**WEST SUSSEX COUNTY COUNCIL
PLANNING SERVICES CONSULTATION**

SUBJECT: LU/278/17/RES - Approval of Reserved Matters following Outline Permission LU/47/11 for Construction of the southern section of the Lyminster Bypass, including northern and southern roundabouts, surface water drainage and landscaping. Departure from the Development Plan and affects a Public Right of Way.

LOCATION: North Littlehampton Strategic Development Site, Land West of Toddington Park, Toddington Lane, Littlehampton, BN17 7PP.

This is the second WSCC highways and transport response to the planning application for approval of reserved matters following Outline Permission LU/47/11 for Construction of the southern section of the Lyminster Bypass, including northern and southern roundabouts, surface water drainage and landscaping.

WYG drawing A0885461/SLB1, SLB2 and SLB3 Dated August 2012

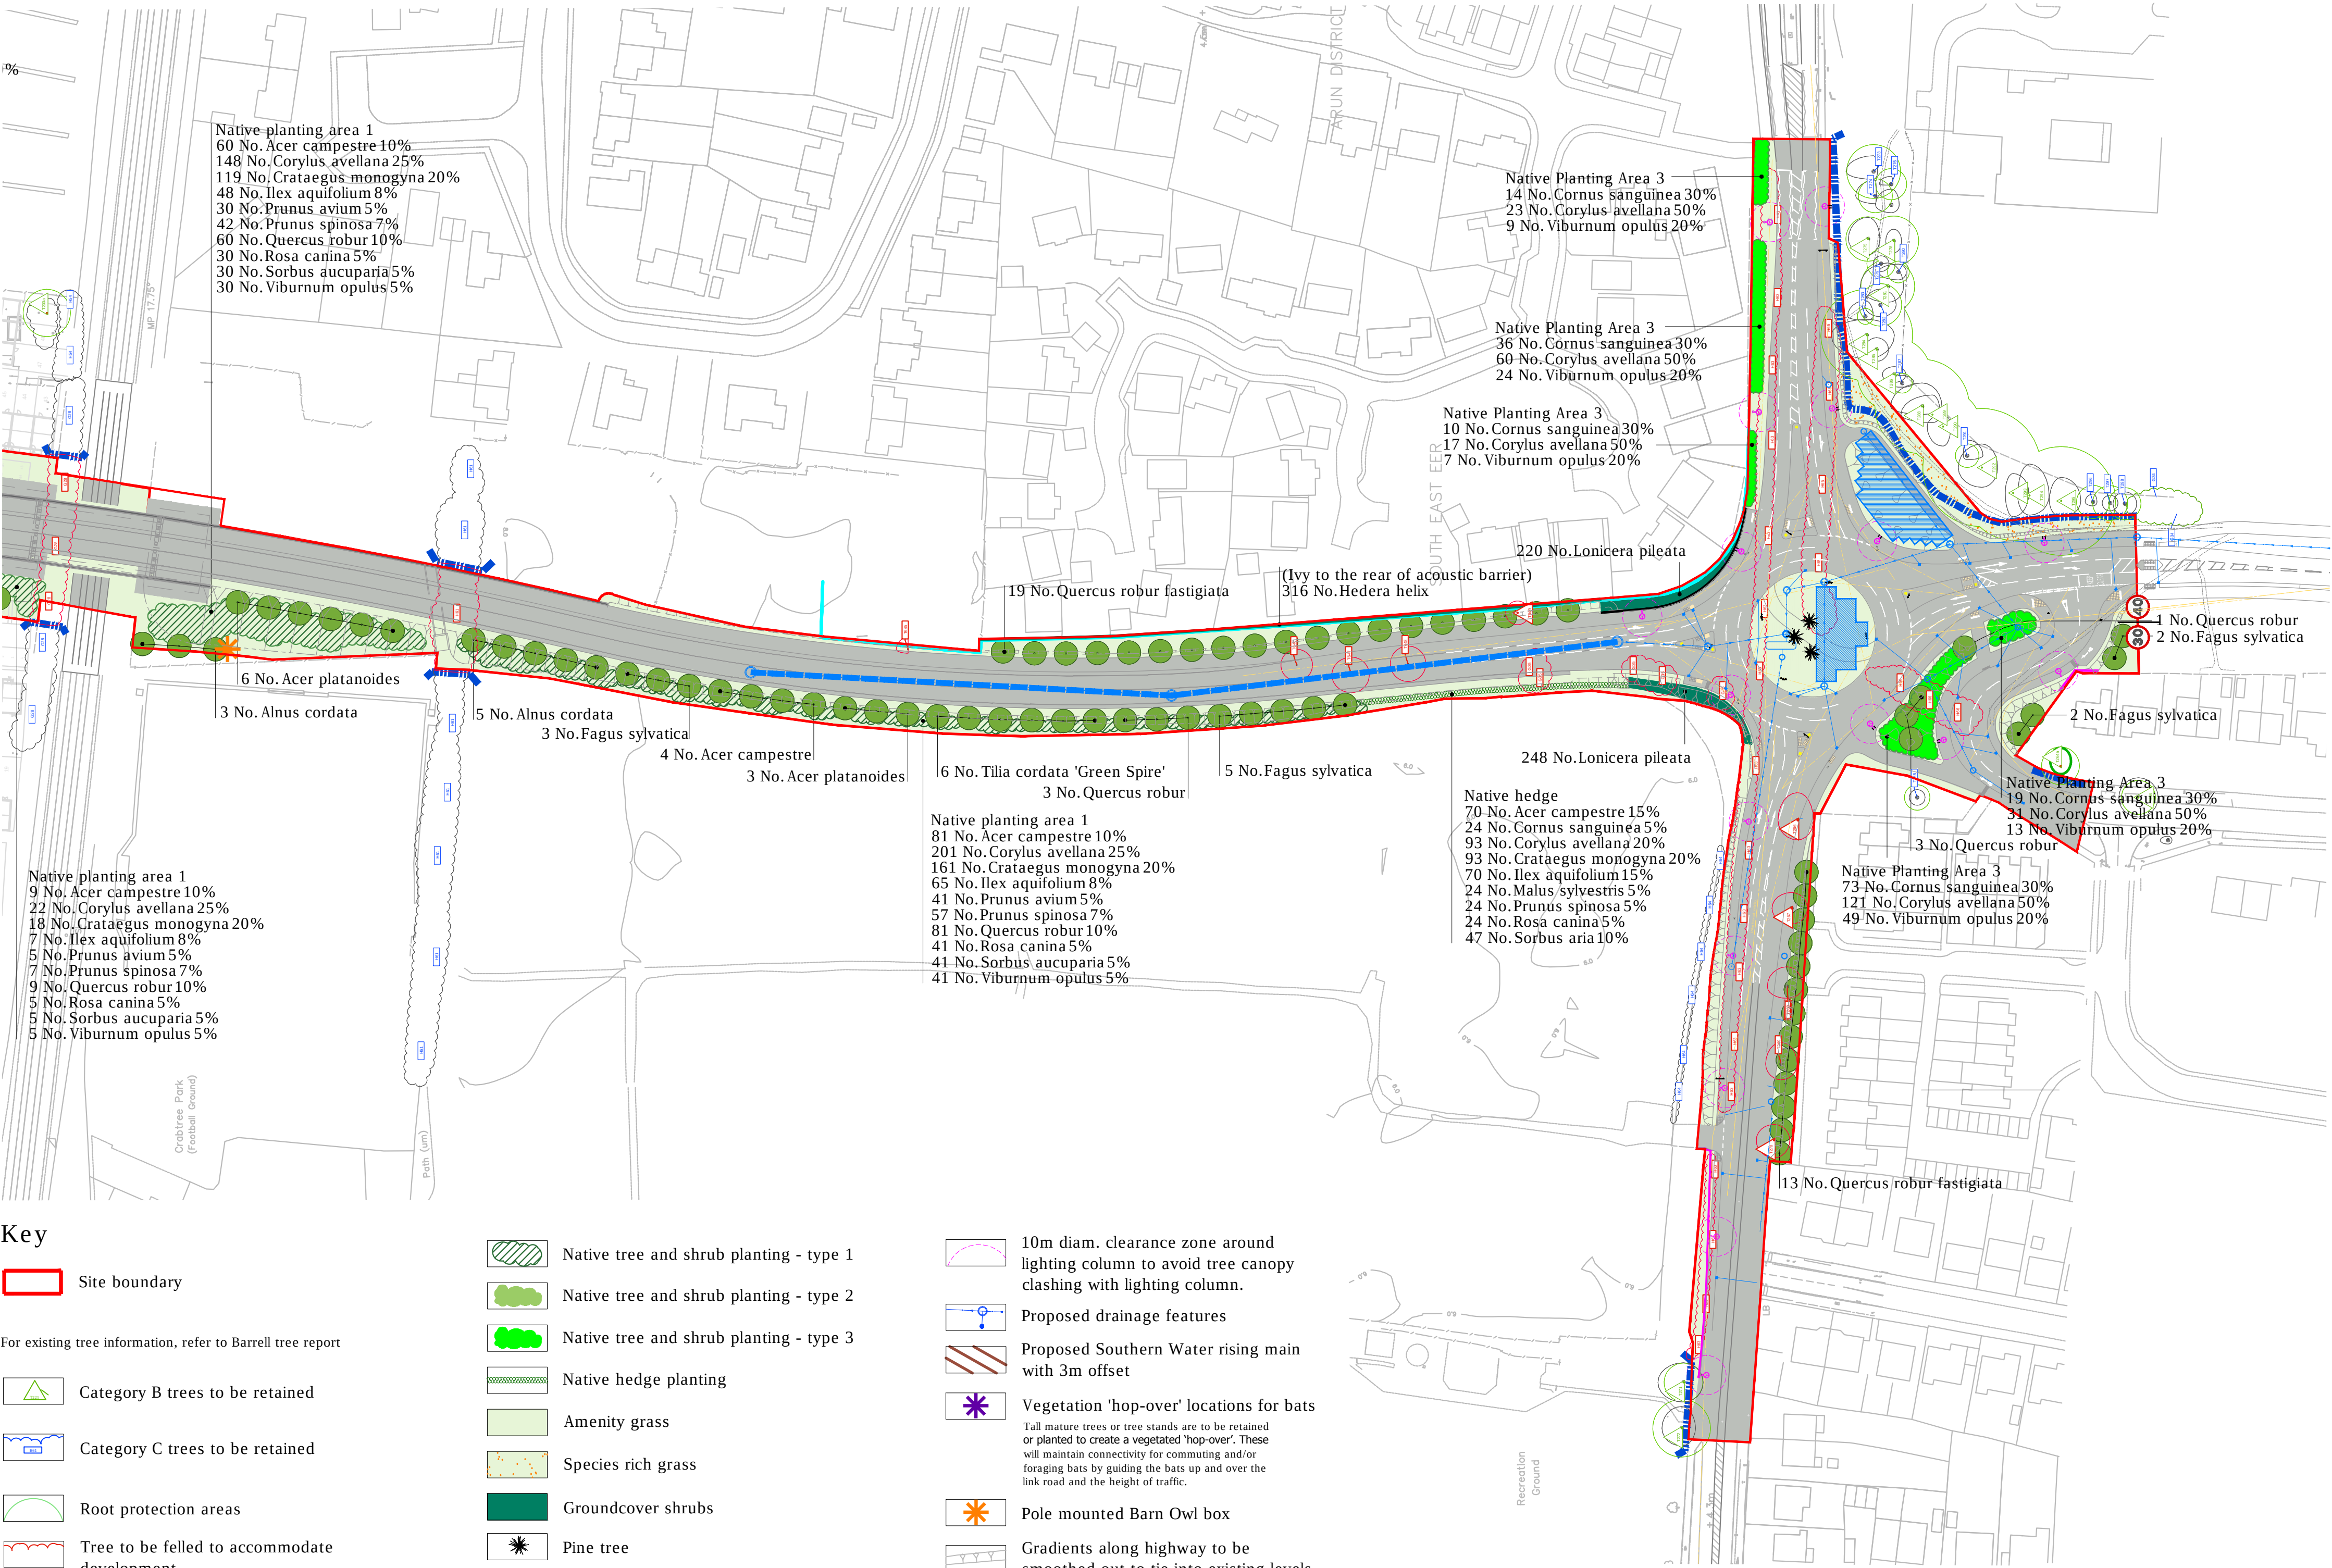
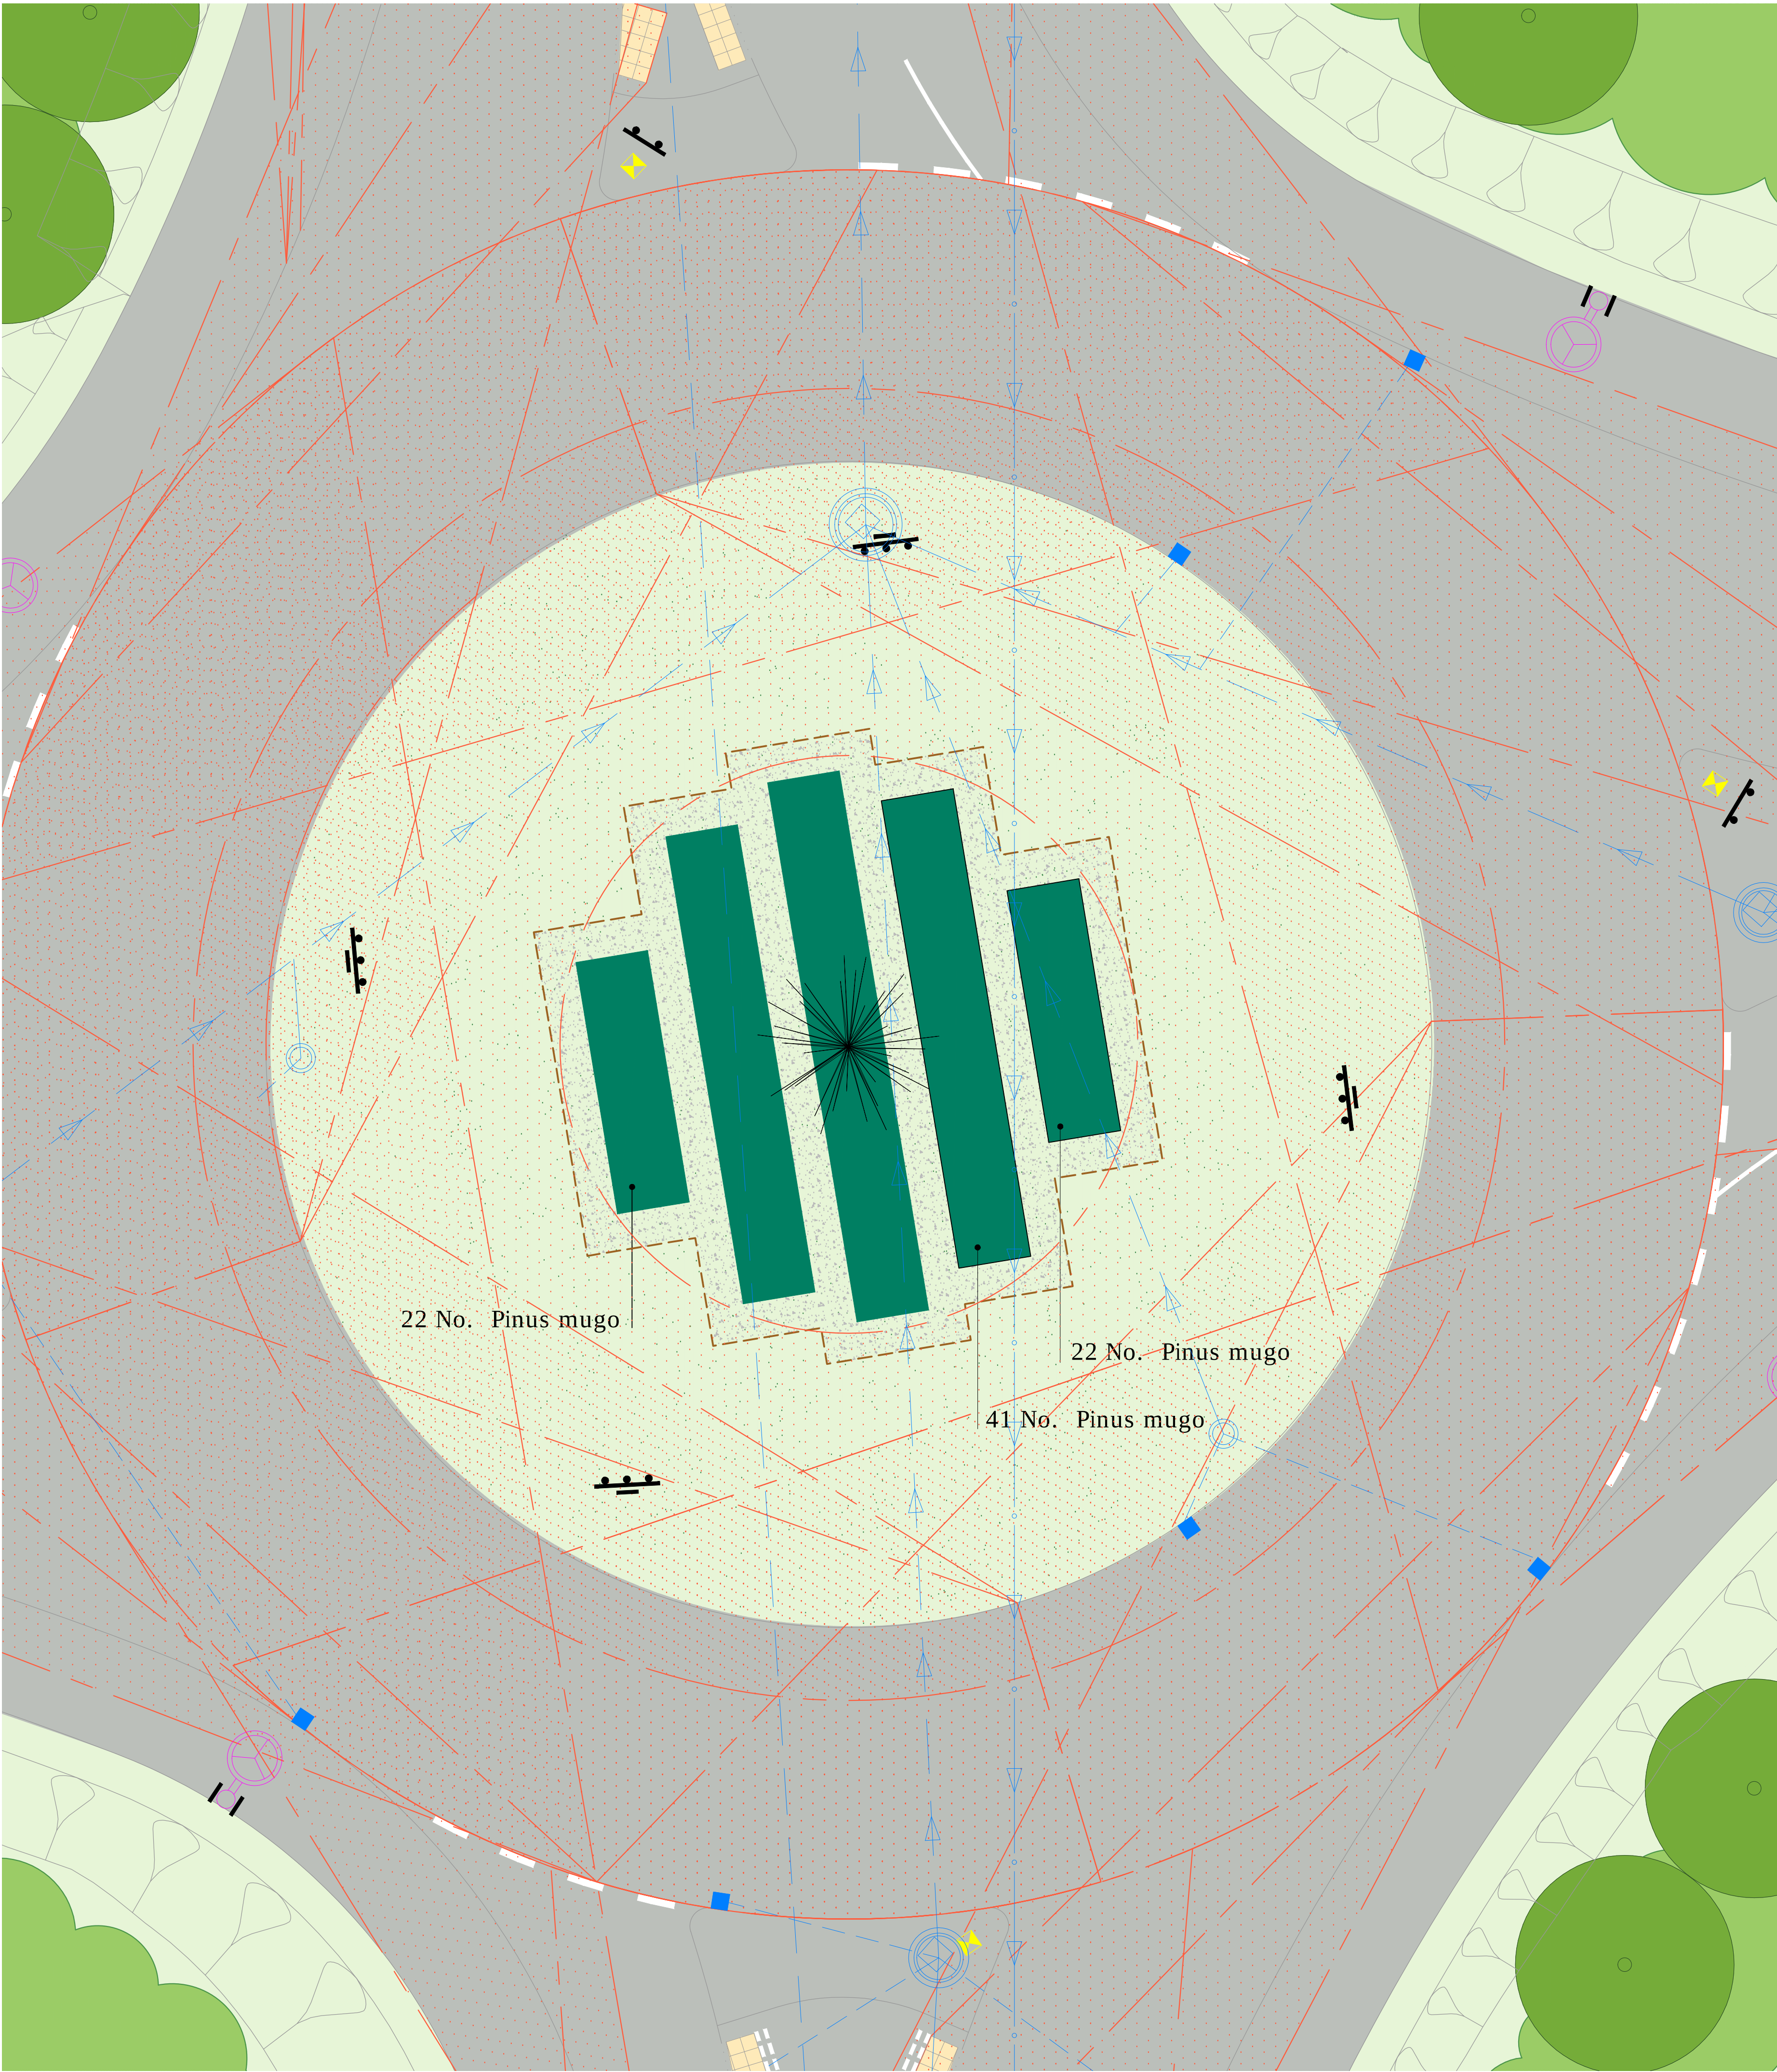
Earlier versions of these drawings had no indication what revision they were. Applicant to confirm final versions.

Comments had also been made previously about having no planting on the cellular storage areas, other than grass. The applicant now appears to have revised this accordingly.

Timber features and ground-cover ivy have been removed from both roundabouts.

For the **Northern roundabout** the underground storage tank has been removed. Pine trees and ground-cover pine are proposed within the centre of the roundabout (outside the visibility splays). For the **Southern roundabout**, the storage tank remains. Pine trees are again proposed within the centre of the roundabout. **Drainage comments to follow separately.**

Regarding planting, the CHA had stated that thorny planting (blackthorn [Prunus spinosa], or otherwise) should not be planted adjacent to or close to cycle paths. The applicant has noted and amended this - Thorny shrubs (Ilex aquifolium, Prunus spinosa, Rosa canina and Crataegus monogyna) have been removed. Sambucus nigra and Salix caprea have been added to the mix. It is not known whether what is proposed will be in the form of individual shrubs or designed/planted as a hedge. This should be made clear before determination of the proposal in order to understand maintenance regime etc.

Owl boxes (and the barn owl box), previously shown too close to road have now been shown removed and re-located.
